From: Laura Gibbons <Laura.Gibbons@arun.gov.uk>
Sent: 15 December 2020 15:37
To: Planning.Responses <Planning.Responses@arun.gov.uk>
Cc: Simon Davis <Simon.Davis@arun.gov.uk>
Subject: RE: Planning Consultation on: Y/141/20/DOC

We have the following comments regarding Condition 9- surface water drainage

Application No: Y/141/20/DOC

Site Address: Land East of Drove Lane Yapton BN18 0EB

133647 – Drove Lane, Yapton
Quick Storage Estimates

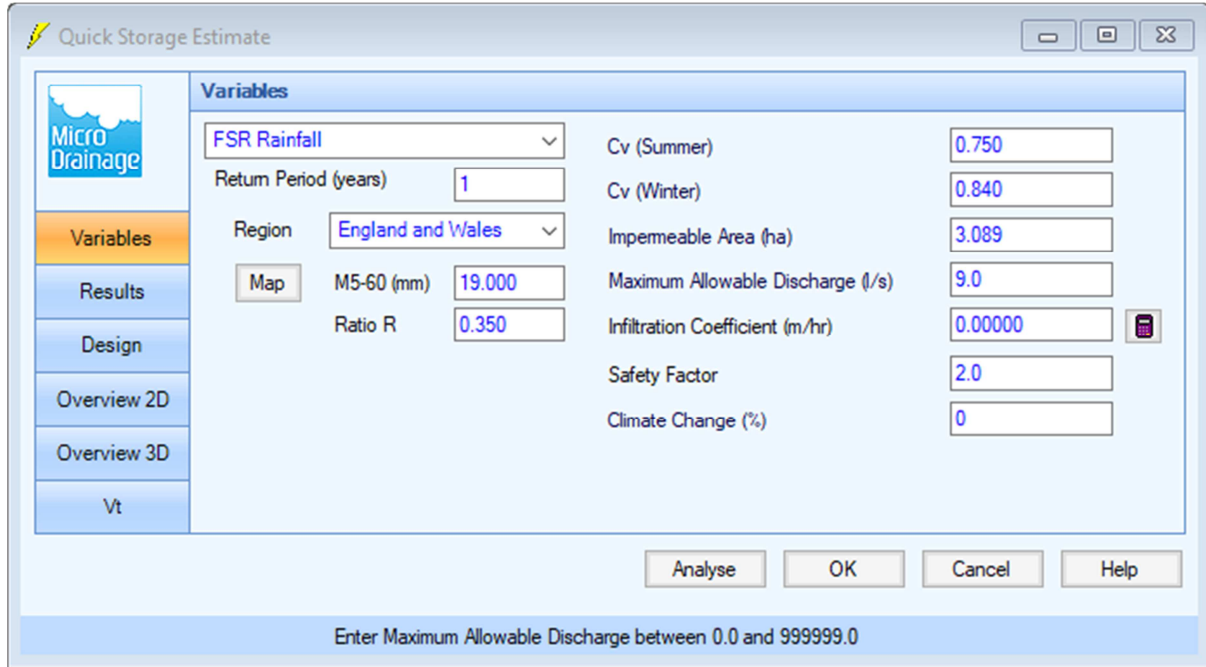
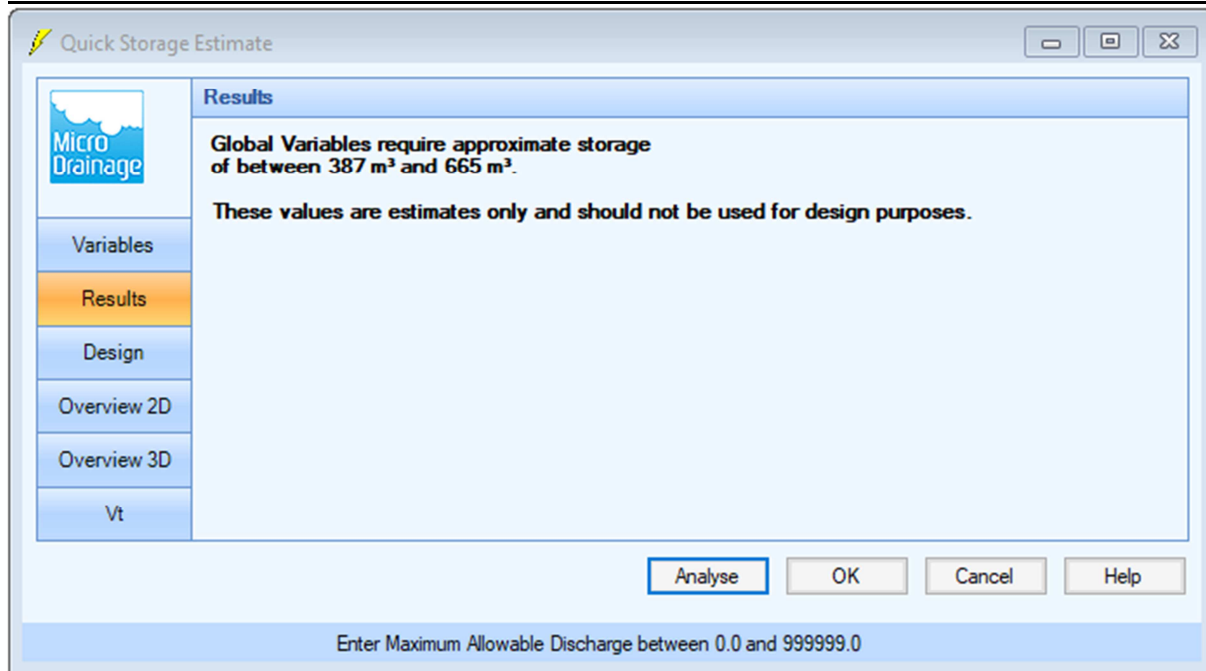
1. The proposed discharge rate is high. Flow restriction to as close to Q1 year for all events up to and including the 1 in 100 year plus 40% climate change event is required to be compliant with policy requirements. We will need to see storage volume being maximised, potentially urbanised area reduced, and further evidence supplied of the discharge rate which is achievable.

2. A full review of calculations has not been completed due to point 1.
3. A buffer plan showing a 3m clear buffer from top of watercourses and proposed surface water drainage attenuation basins is required to demonstrate that these can be maintained.

7. Confirmation of whether an urbanisation allowance has been applied to calculations is required. If an allowance has not been applied then this must be. Given the density of the site it is anticipated that this allowance should be 10%.

8. A cv of 1 or latest FEH data must be used in calculations.
9. An impermeable areas plan must be provided.
10. Groundwater monitoring results and a location plan must be supplied as part of the DOC application.
